WELWYN HATFIELD COUNCIL – DEVELOPMENT CONTROL
DELEGATED REPORT

APPLICATION No:	N6/2007/1290/FP
ESTATE MANAGEMENT APPLICATION No:	W6/2007/1293/EM

The application is for the erection of a replacement detached garage on the south eastern side of the property. The flat roofed garage is stepped back from the dwelling and runs along the boundary of the site with Scholars Mews. The garage is proposed to be rebuilt 0.5m longer in length and 0.3m wider than existing. The height would be increased from 2.4m to 2.95m including the parapet finish to the roof.

PROPOSED GARAGE
PLAN & ELEVATIONS

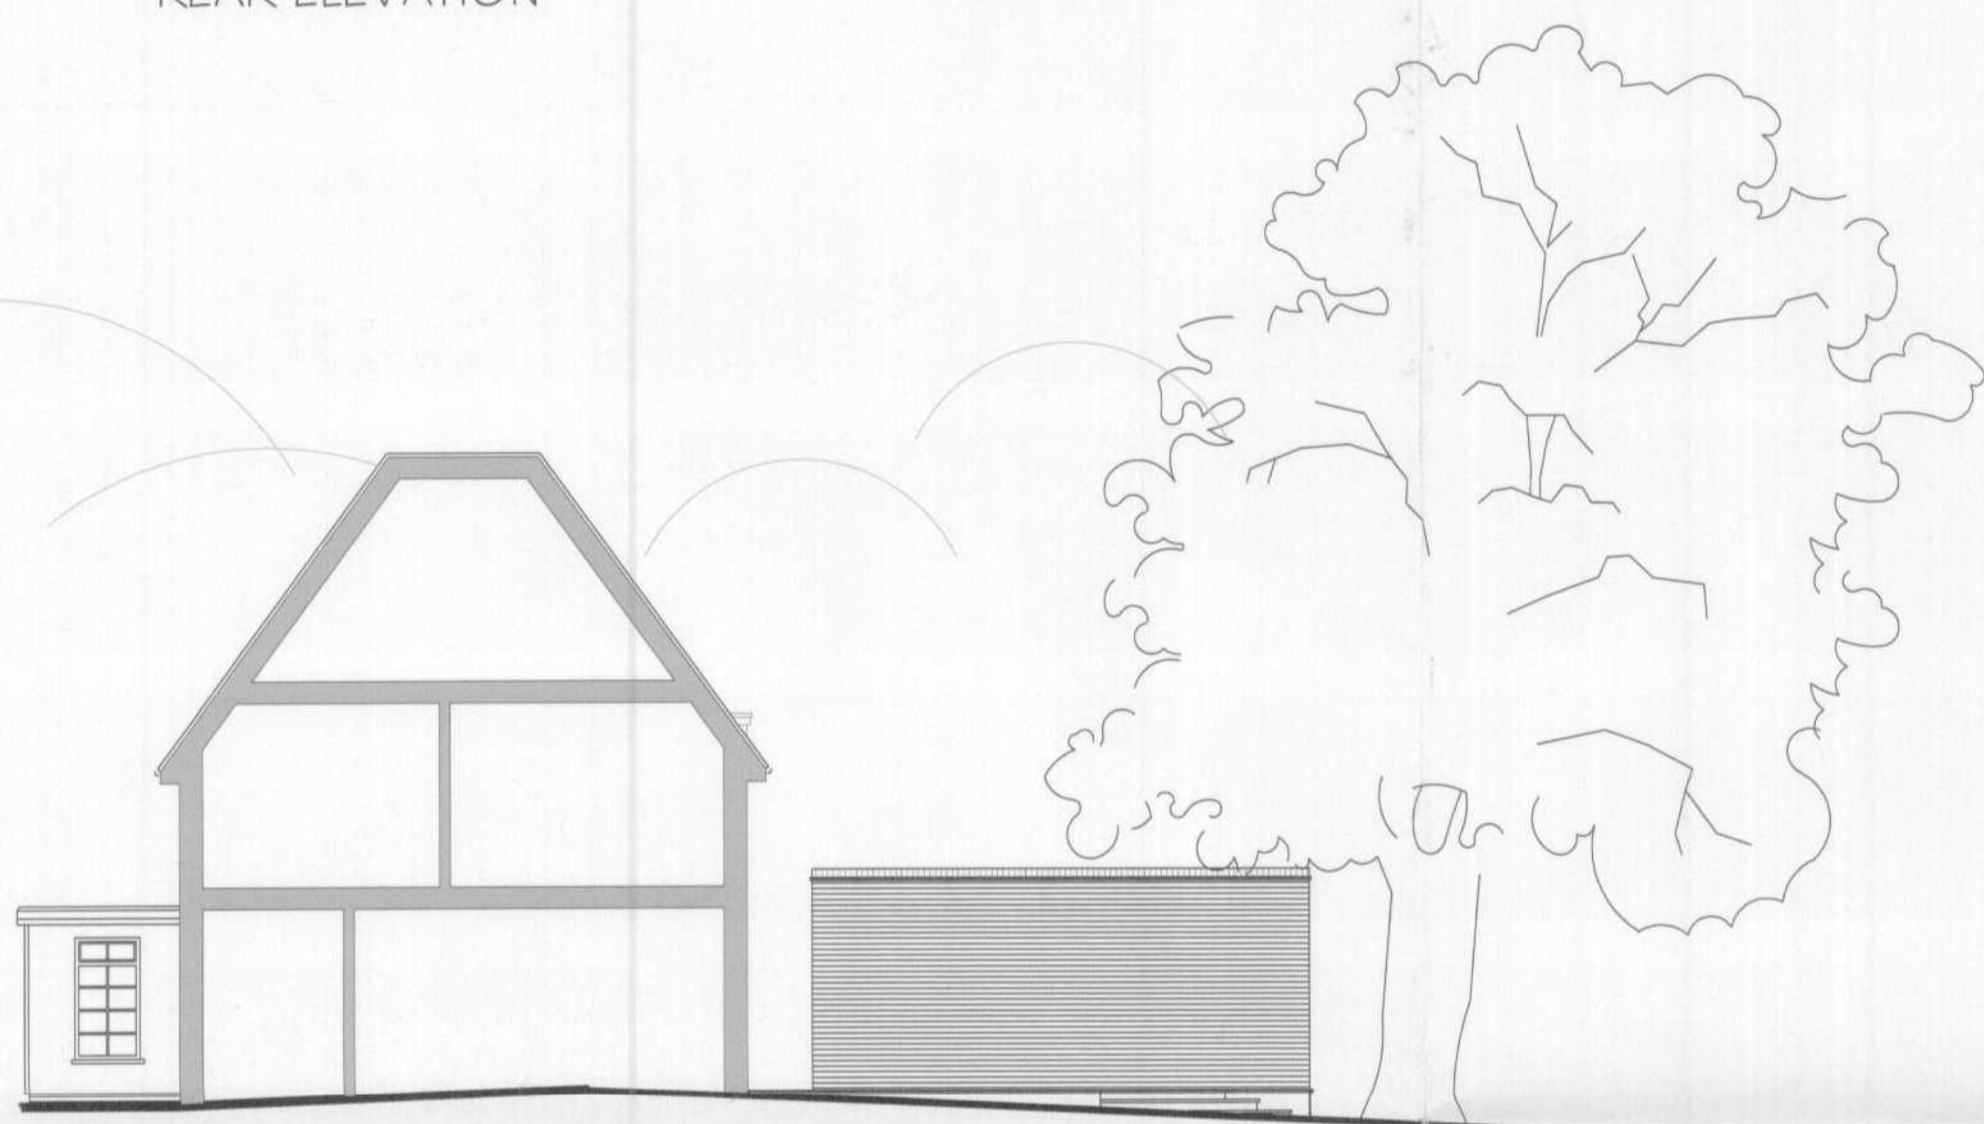
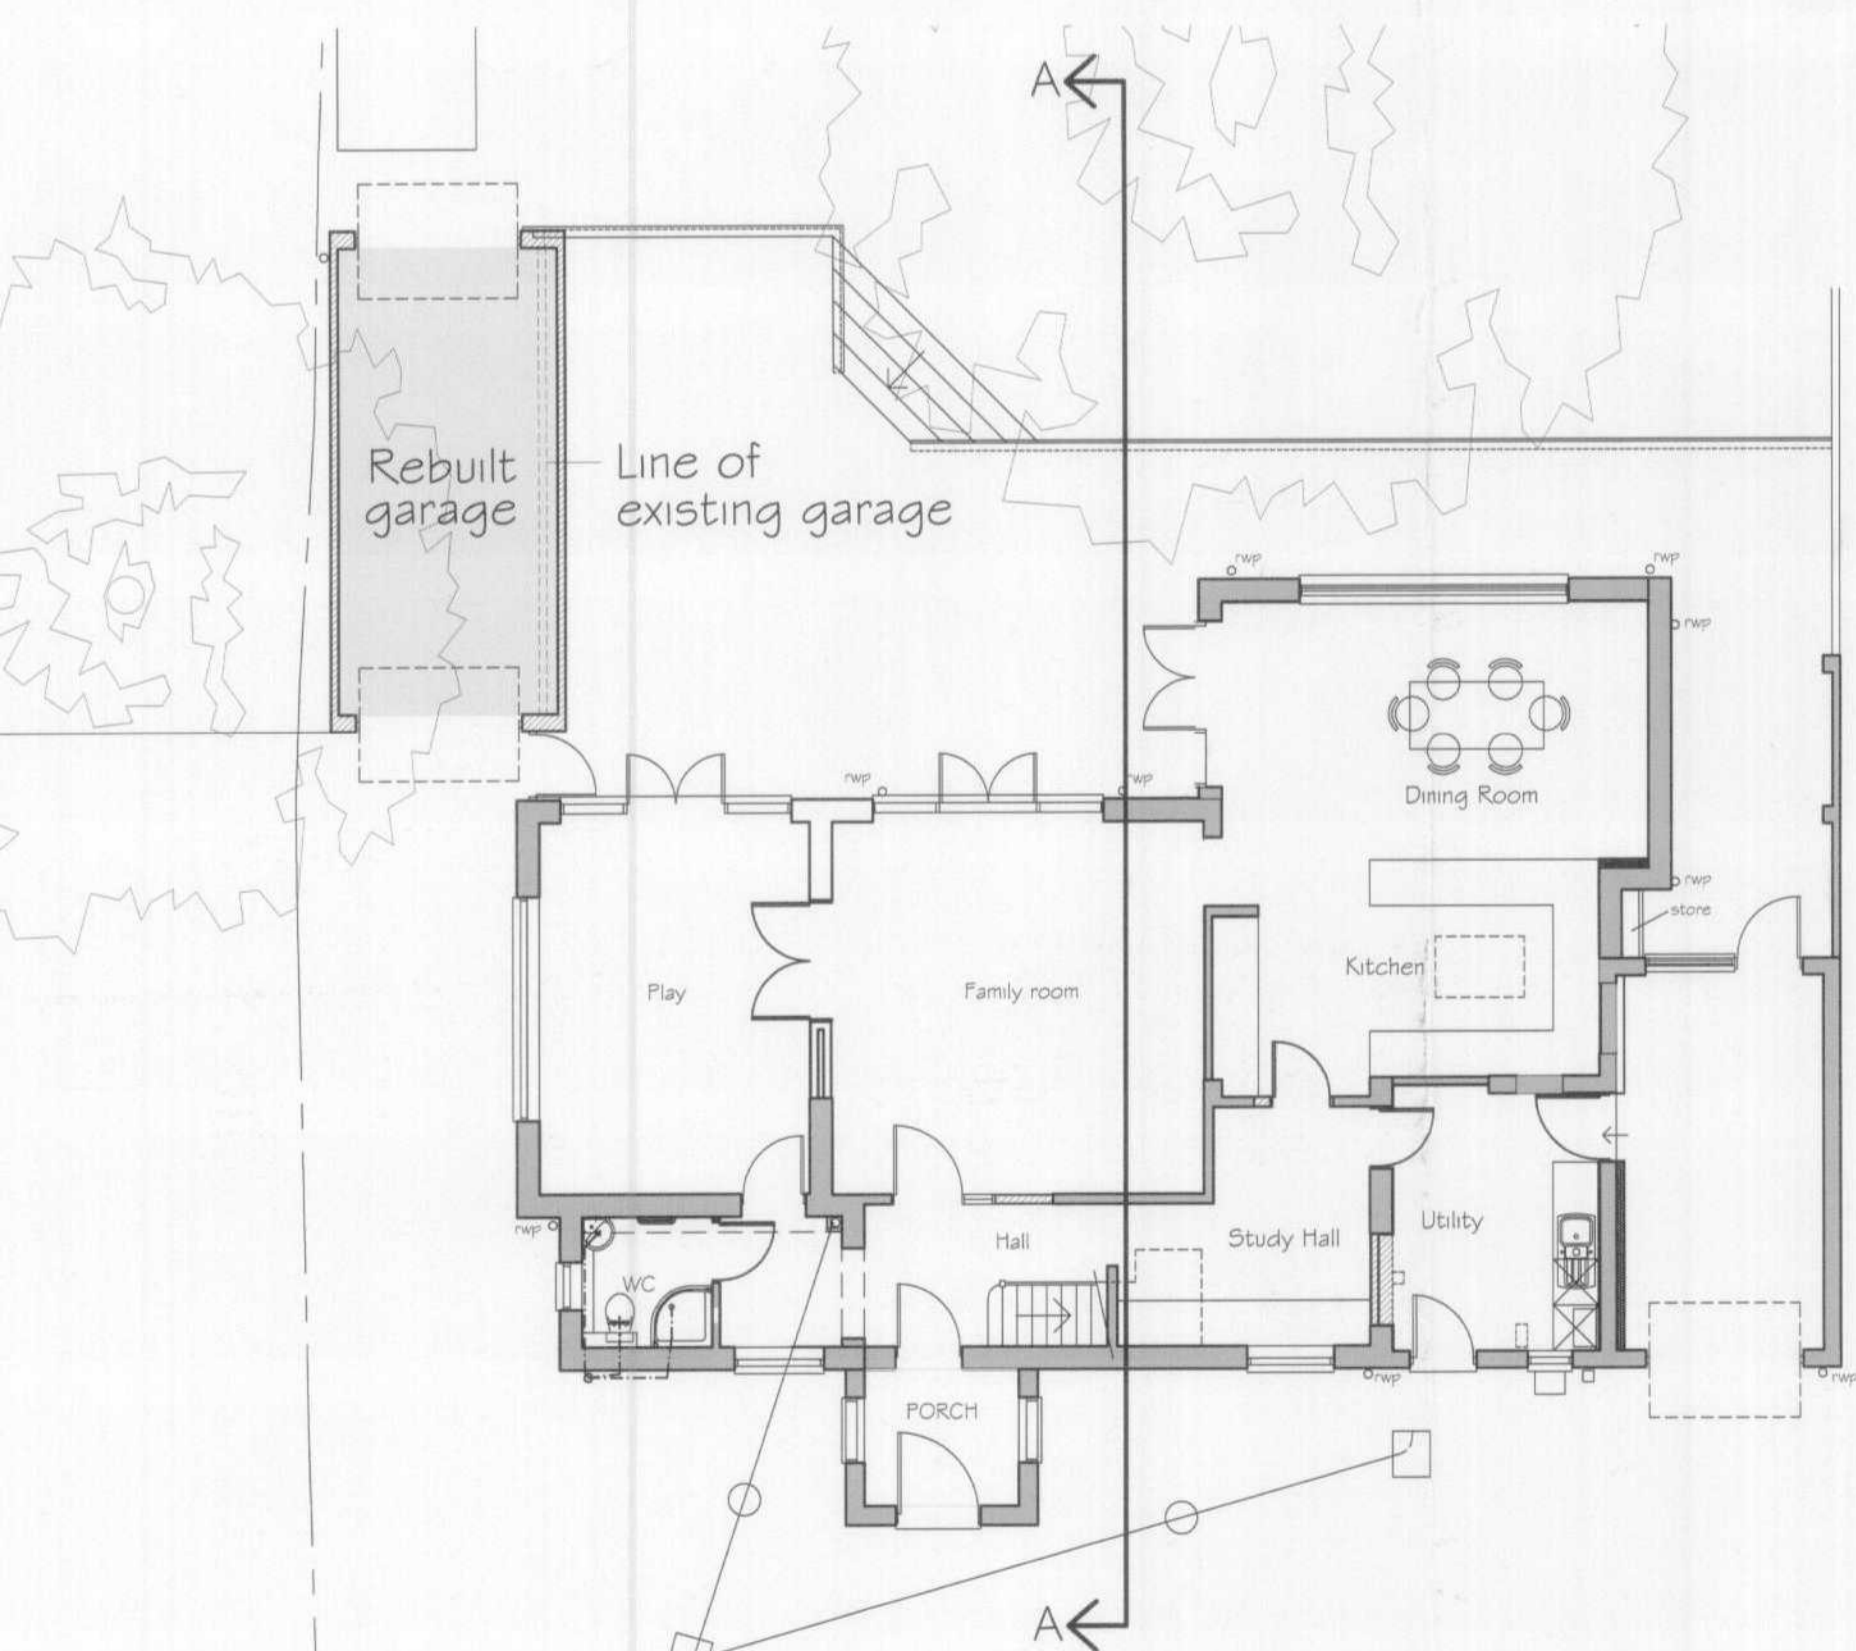
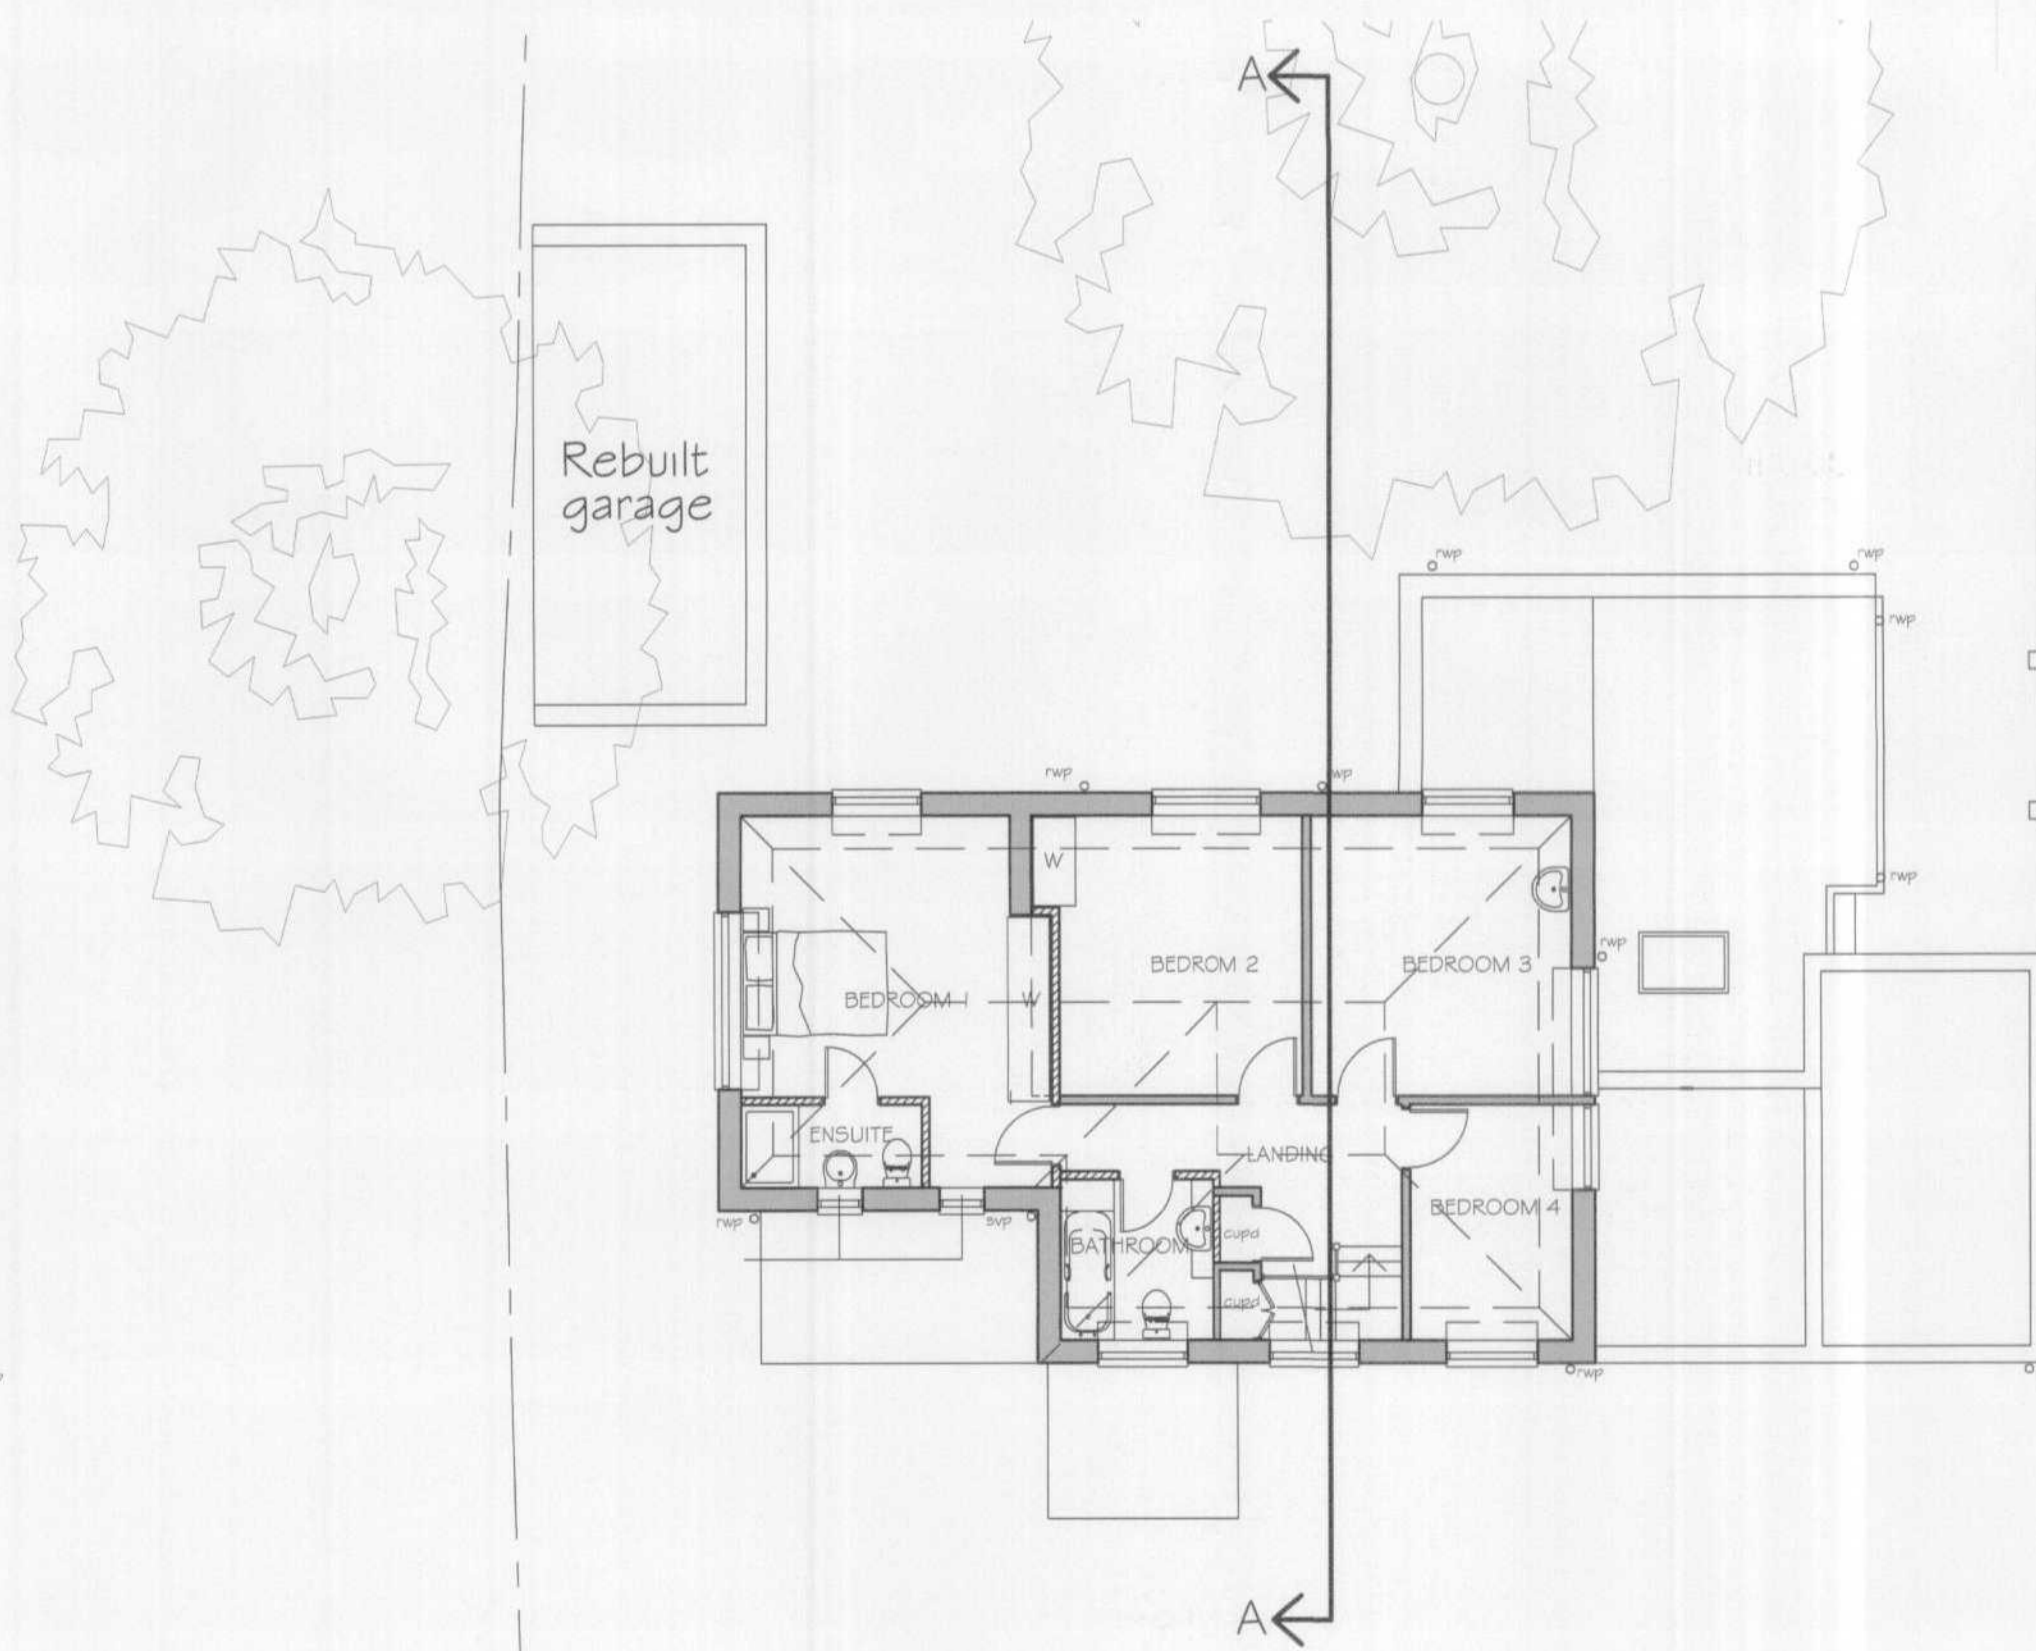
Council's arborist – considers that there is a need for a foundation design as it needs not to be below ground. They state that that the trees near to the garage are important and in need of protection and if there is not information available a condition would be appropriate.

Overall the garage would be enlarged by a small amount; the main addition noticeable in the surrounding area would be that of the increase in height by 0.55m. This would however sit below the level of the approved rear extension visible behind it. It is not considered that the rebuilt garage would be out of keeping with the character of the site or surrounding area provided that materials match existing.

3. Prior to commencement of works on site, details relating to the proposed foundations for the garage shall be submitted to and approved in writing by the Local Planning Authority. Any subsequently approved details shall be implemented in full unless otherwise agreed in writing by the Local Planning Authority.
